Anthony Jones and Dawn Davis-Jones (Dawn J. Valleroy) property owners of 7750 Mohawk Rd, Colorado Springs, Co 80908 want to convert our barn on five acres (698.08' x 312') into an office/recreation room for personal use and as a guest house for when relatives visit. Their occupancy would be temporary (about one or two days over a weekend, once or twice a month), but Anthony and Dawn would use the area more often.

Letter of Intent

In 1985 a 20ft setback was approved for livestock in my barn, but no animals are there now. I am converting it into a recreation office/guest house that needs a bathroom and septic system, which requires a 25ft setback. I am requesting Administrative Relief from El Paso County Planning and Community Development Department for this purpose.

7750 MOHAWK ROAD
LOT 2, BL 2 PAWNEE
RANCHEROS FILING 1

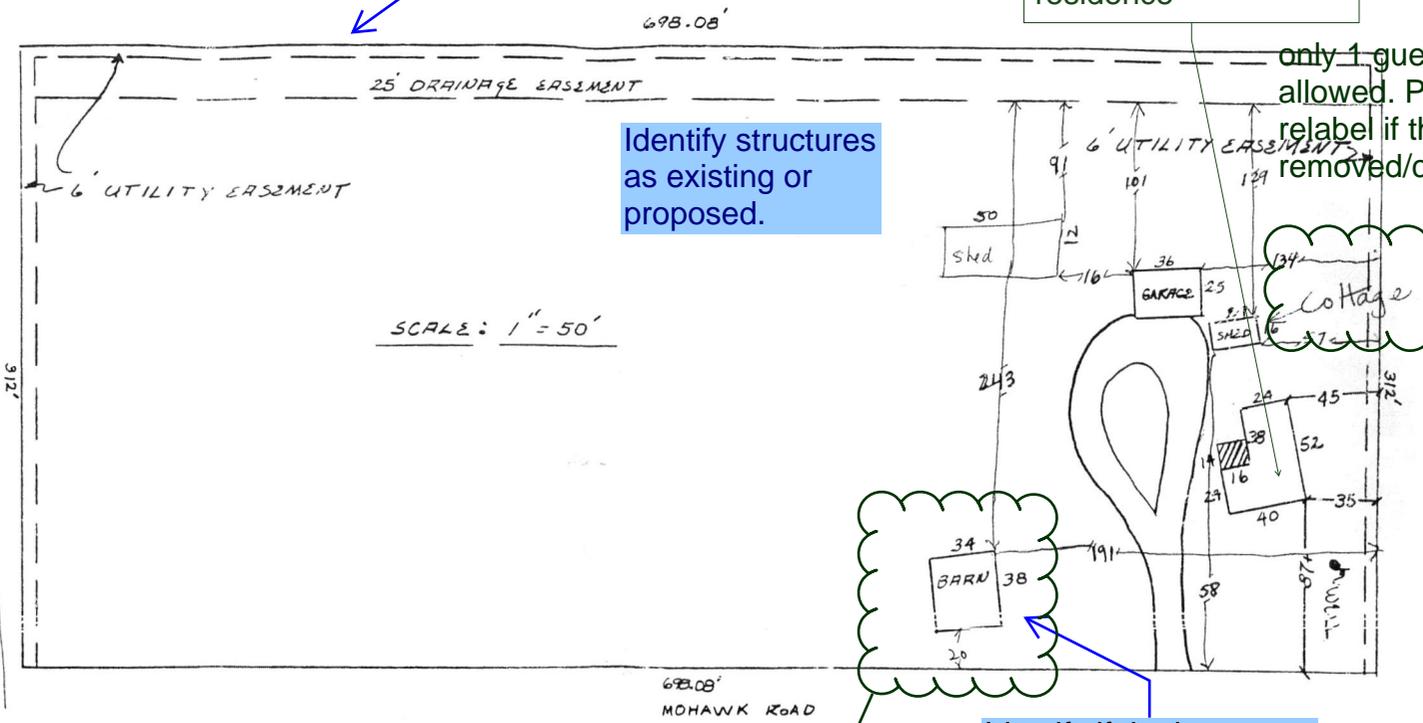
It does not appear that a driveway access permit is on file with El Paso County for the existing access location. A driveway access permit must be obtained.

Clarify if the barn will access off of the existing driveway access location or if a secondary access location is proposed.
